Engineers Comments Regarding Surface Water Drainage

Application Reference:	WA/51/26/RES	Reviewer Reference:	ADC/EXT5/AF
Planning Officer:	Simon Davis	Date of Review:	27/07/2026
Site Name:	Land East of Wandleys Lane Fontwell		
Application Description:	Approval of reserved matters following the grant of outline planning permission WA/35/23/OUT, for the construction of 95 No. new homes, access, new pedestrian and cycle links, open space, landscaping, habitat creation, drainage features and associated groundworks and infrastructure, including details relating to the Sensitive Lighting Strategy, POS details and Part M Compliance. This application is in CIL Zone 3 and is CIL Liable as new dwellings.		
Assessment Number:	1

Drawing Title
**DRAINAGE STRATEGY
SHEET 2 OF 2**

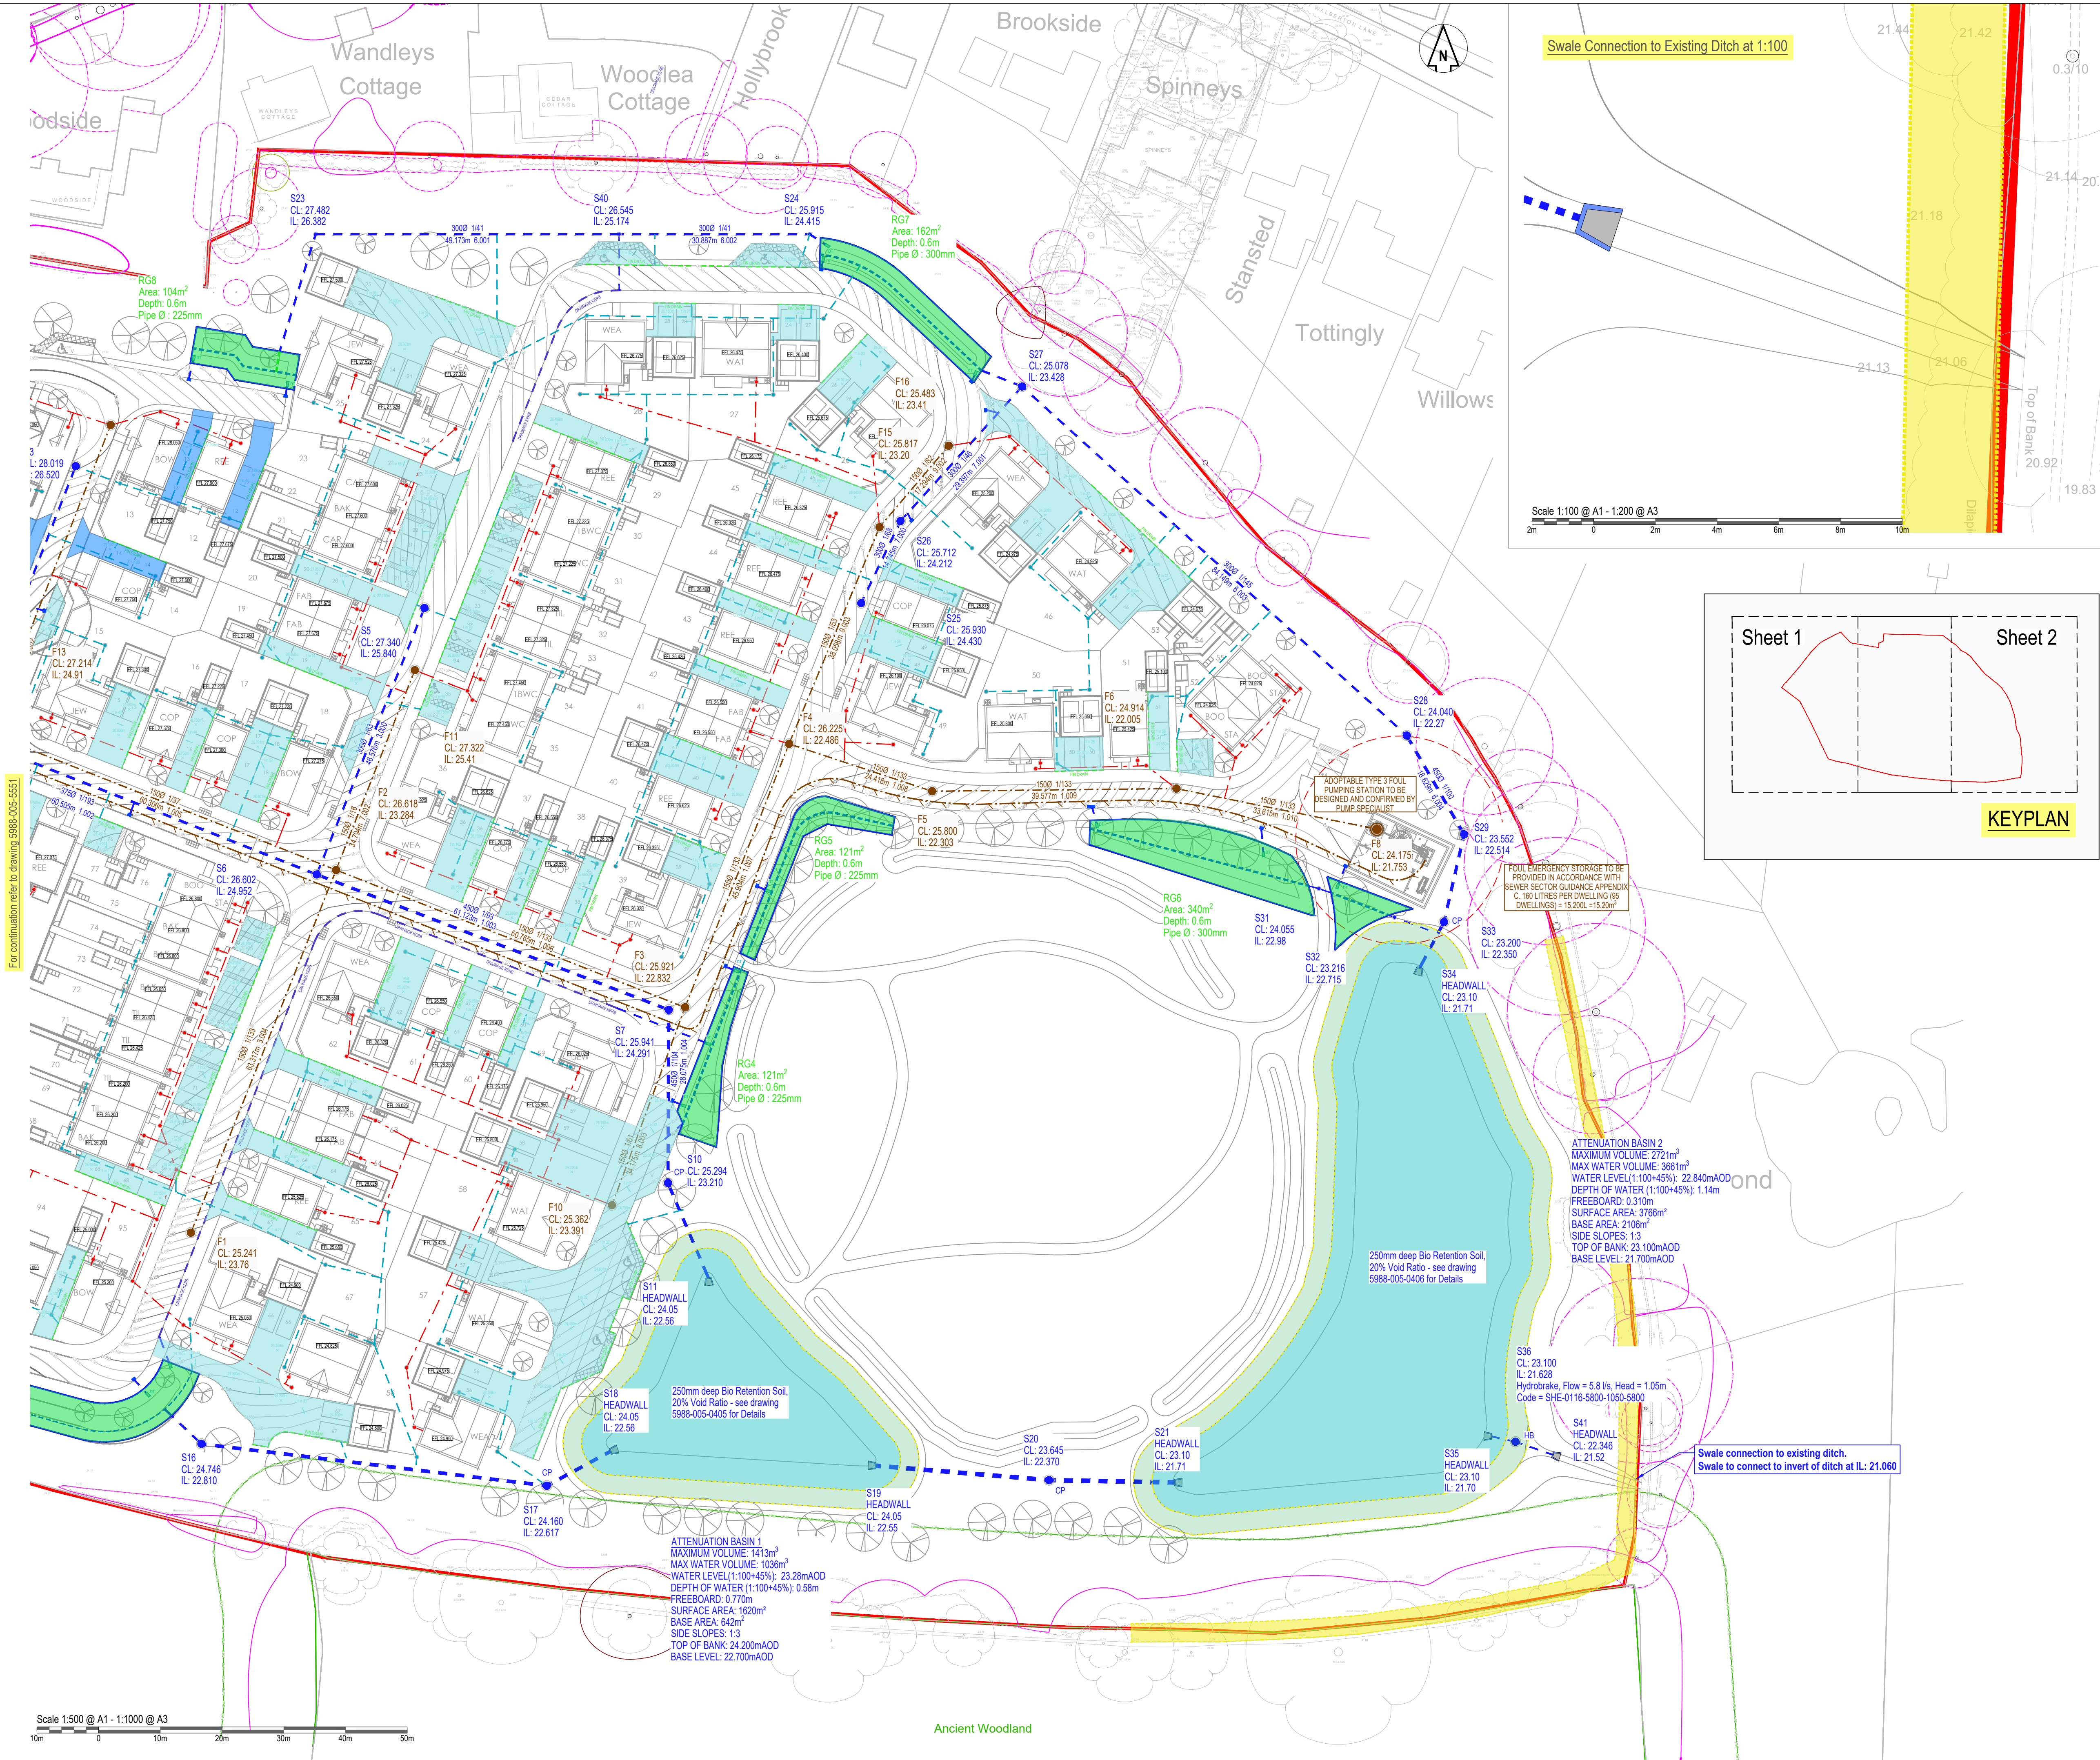
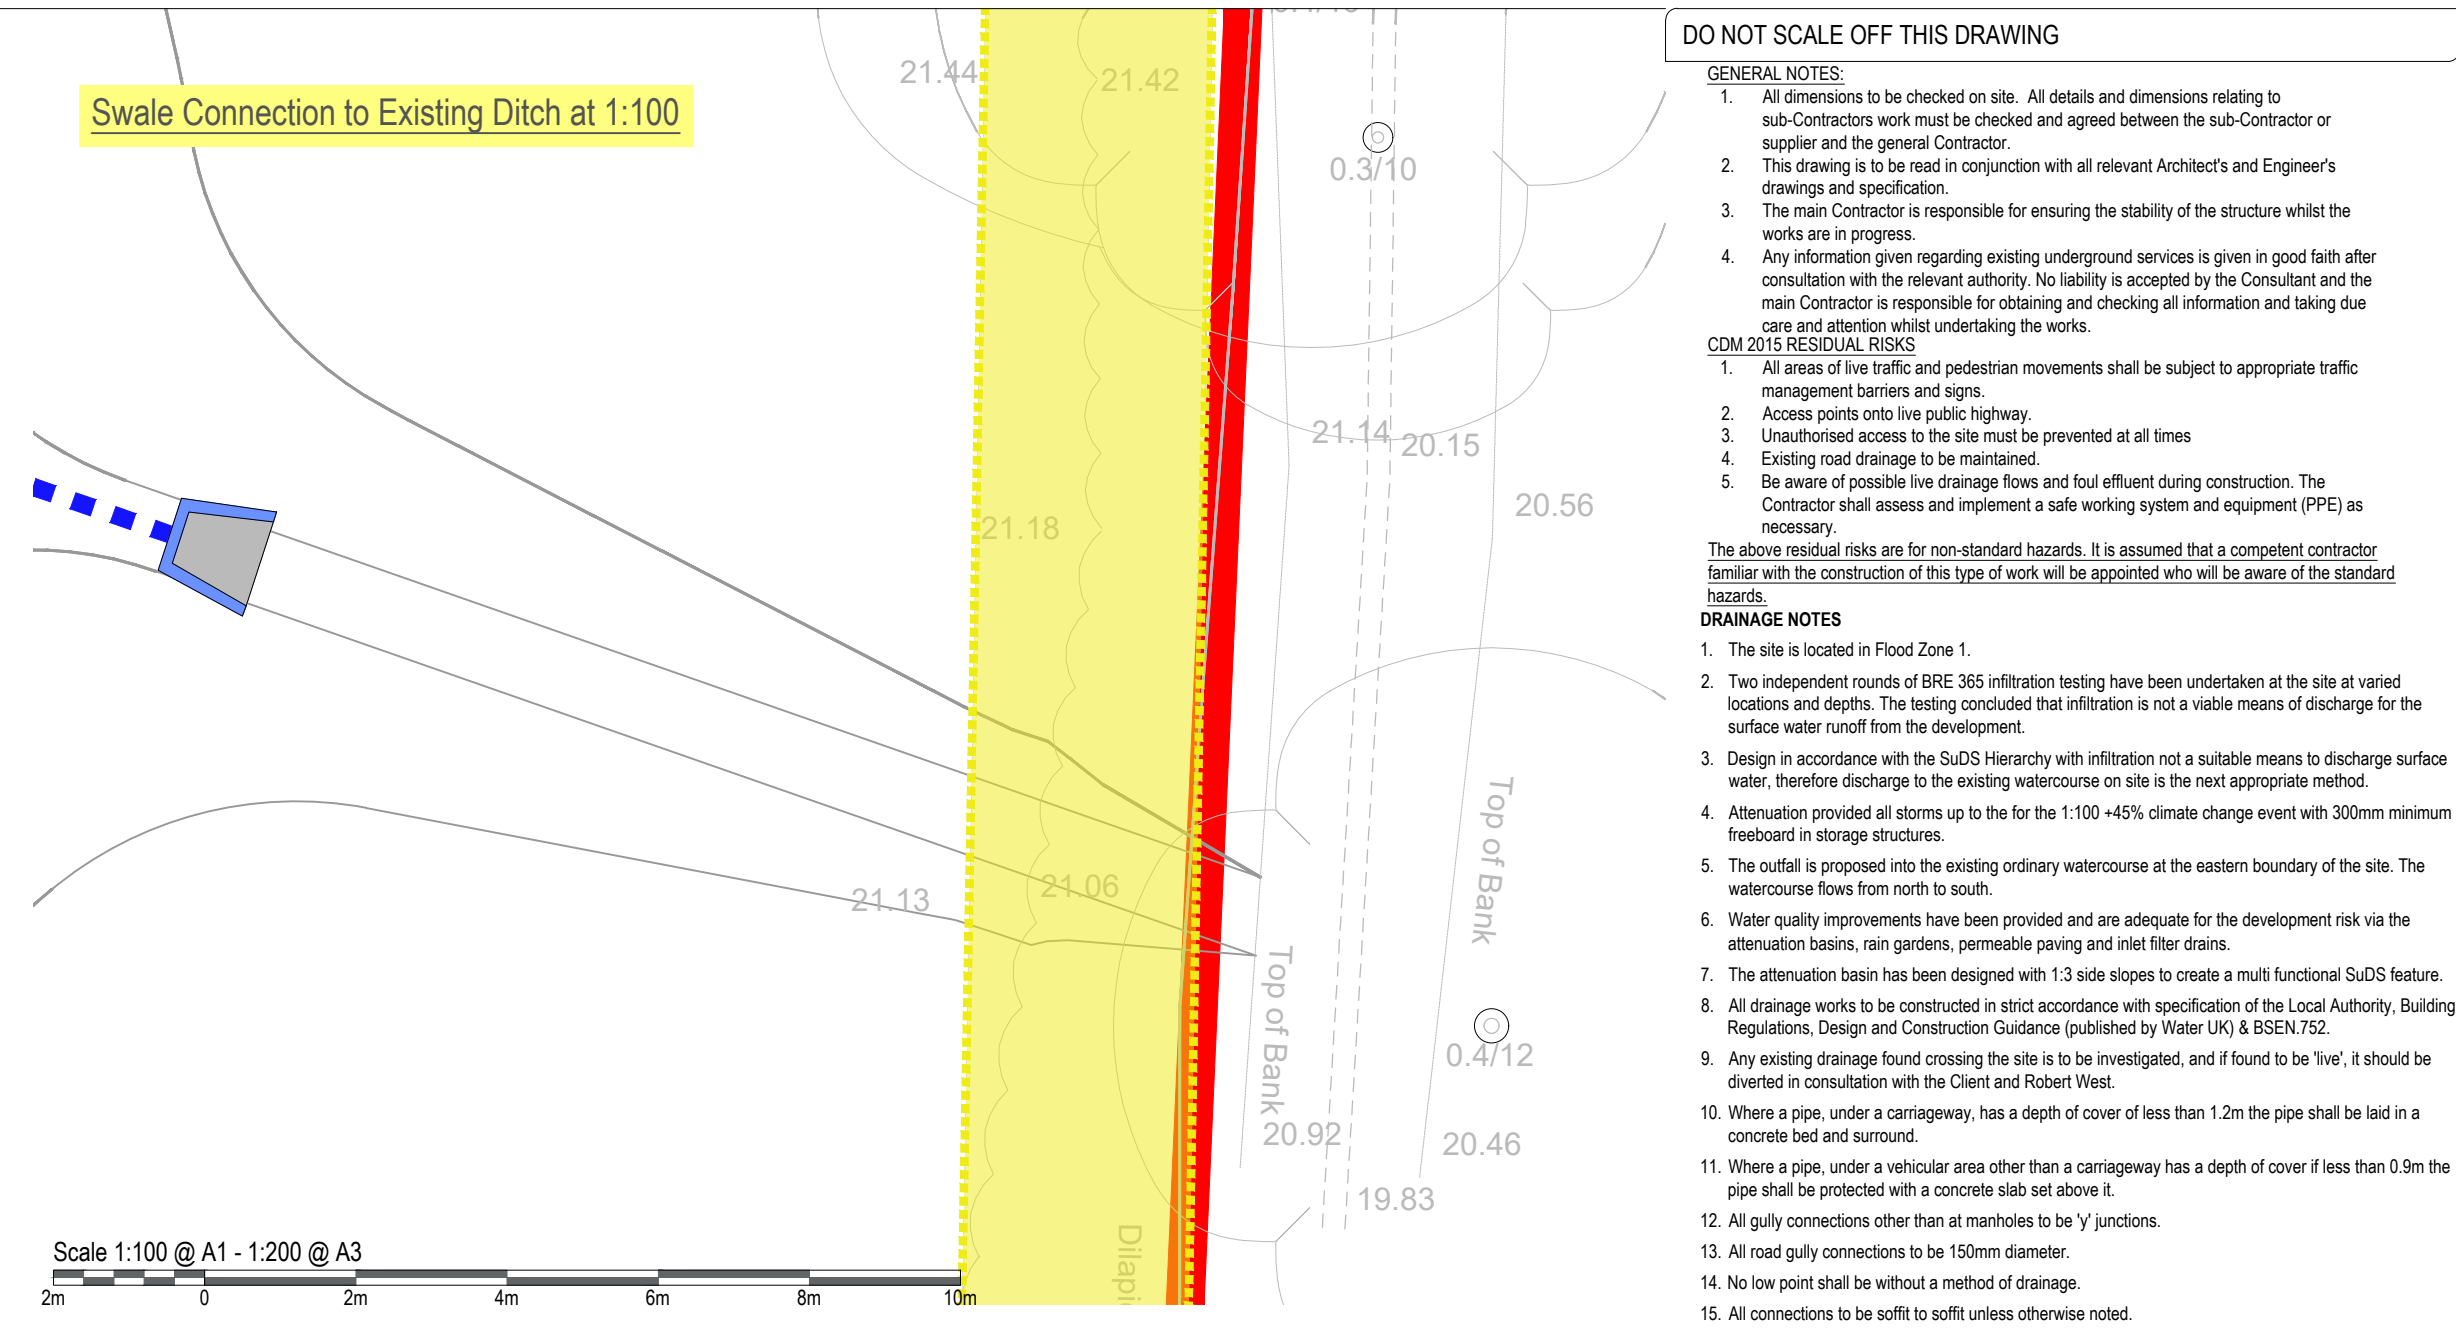
- 1.3. The proposed runoff destination is similar to the outline strategy, which is to the southeast edge of the site where there is no topographic survey but the drainage layout states: 'existing ditch'. It is not clear whether the existence, connectivity and suitability of the outfall was established at outline planning stage. The applicant should submit evidence in support of this current design to demonstrate feasibility subject to final technical design.

- 3.2. It is not clear whether a downstream surcharge is needed to represent the downstream top water conditions in the receiving watercourse during the design storm.

- 3.4. It is not clear from the calculations whether the base gradients for the permeable paving are in accordance with the design. Base levels should be added to the drainage layouts and base gradients confirmed and reflected in the calculations.

condition, with no obvious constraints identified, and the proposed connection was considered suitable and acceptable. Whilst the walkover cannot definitively confirm downstream hydraulic capacity, supporting connectivity mapping indicates that the ditch connects to the wider drainage network. An outfall inset has also been added to drawing 5988-005-5552, Drainage Strategy Sheet 2 of 2, Rev A04, to provide further detail of the proposed connection.

A downstream surcharge is unlikely however we have updated the calculations to include a surcharged outfall. These have been included in the resubmission. To better detail the connection an inset has been added to drawing 5988-005-5552 Drainage Strategy Sheet 2 of 2 A04

Base gradients added to layout along with periodical invert levels for the formation of the permeable paving. These updates can be seen on drawings 5988-005-5551 Drainage Strategy Sheet 1 of 2 A03 and 5988-005-5552 Drainage Strategy Sheet 2 of 2 A04.
